From: Marcus, Dylan <Dylan.Marcus@pse.com>
Sent: Wednesday, April 17, 2024 1:49 PM
To: Bradley Gasawski
Cc: Meldrum, Sam; Leyritz, Brandon
Subject: RE: RU-24-00001 Horish - Notice of Application - Comment from PSE

Subject: RU-24-00001 Horish - Notice of Application

### Proposed Access Driveway

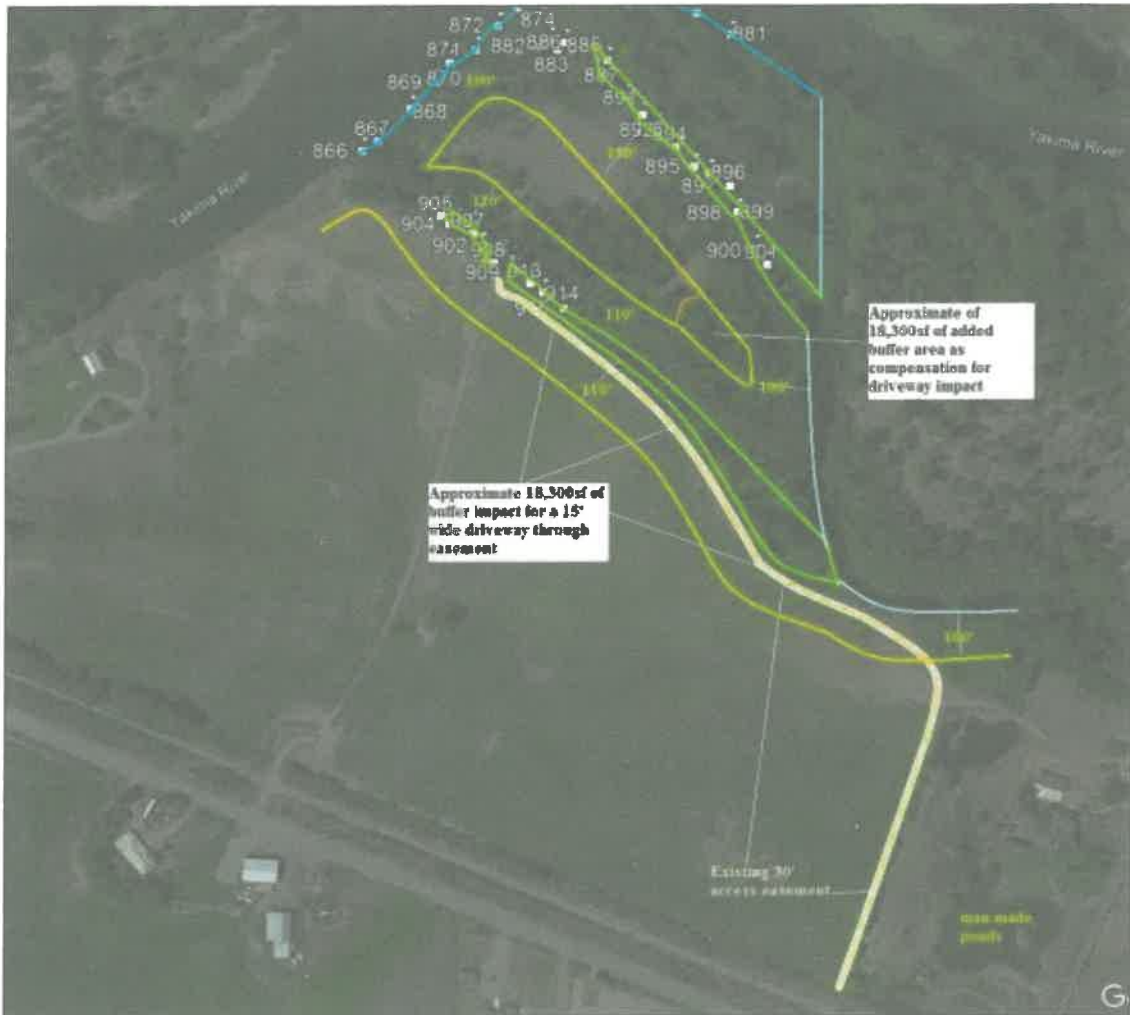
PSE would like to note that in addition to planning for the development of a driveway in the easement area described/depicted in this application, the applicant – should they wish to connect to PSE’s system to the south of the property – must also plan for utility service lines to be accommodated in a format that can be permitted (overhead and alongside the driveway or underground).
